From: Rich Elliott <elliotttr@kvfr.org>
Sent: Tuesday, November 13, 2012 5:39 PM
To: Jeff Watson; Dan Valoff
Cc: Joe Seemiller; John Sinclair
Subject: RE: Kittitas County Notice of Application

KVFR Feedback –

[SP-12-00006 OKeefe No 2](#)

O'KEEFE NO. 2 SHORT PLAT

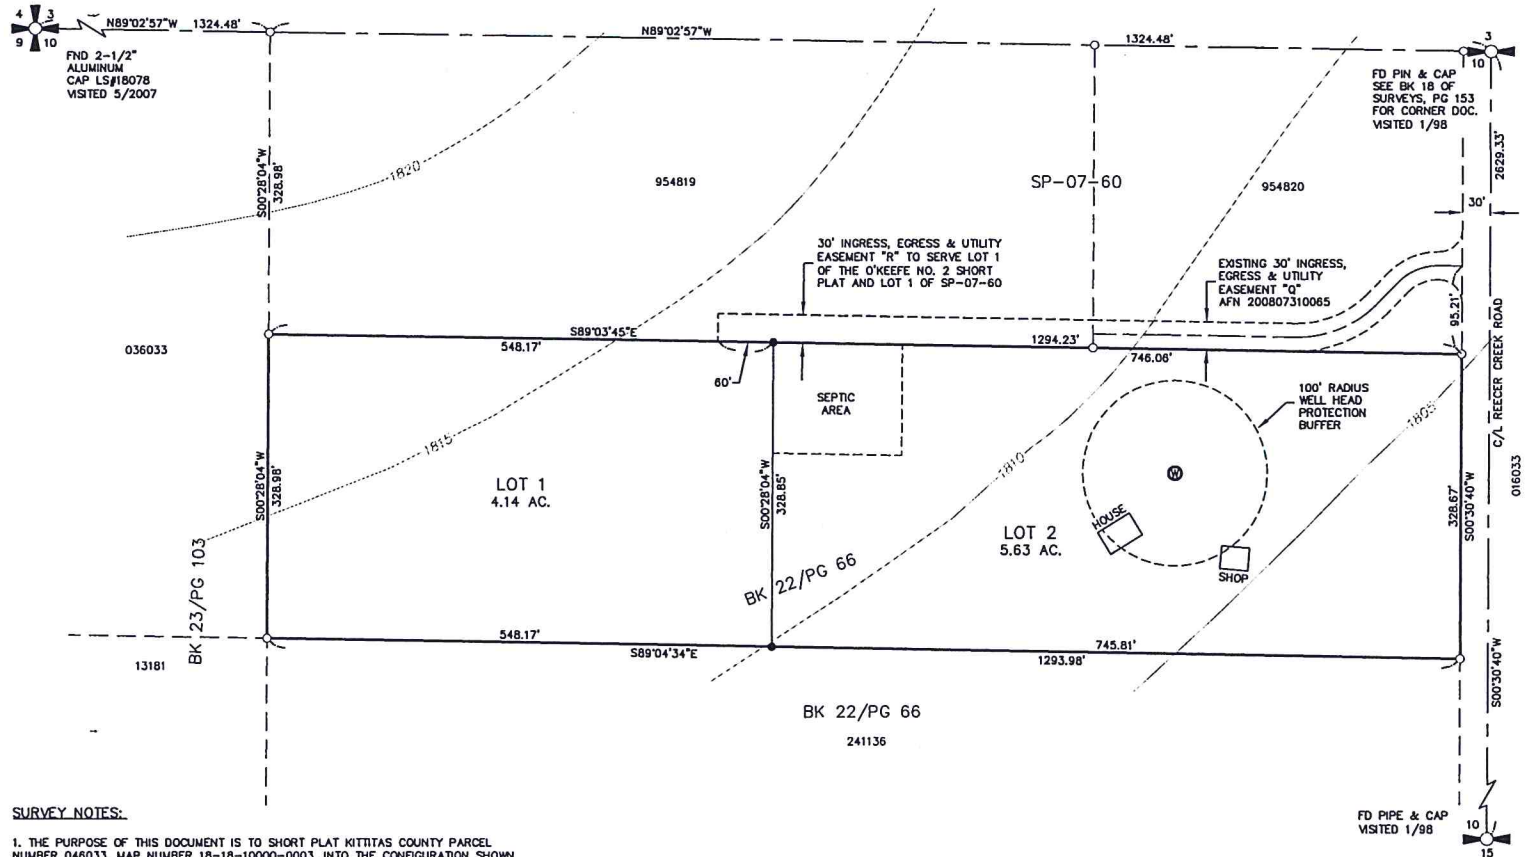
- The address(s), when the property is developed will need to be clearly visible from both directions of travel.
- Access will need to be compliant with Appendix D of the current fire code when the property is developed.
- Depending on the WUI Code decision, the Wildland Urban Interface Code may apply to construction at the time the building permit(s) are issued.
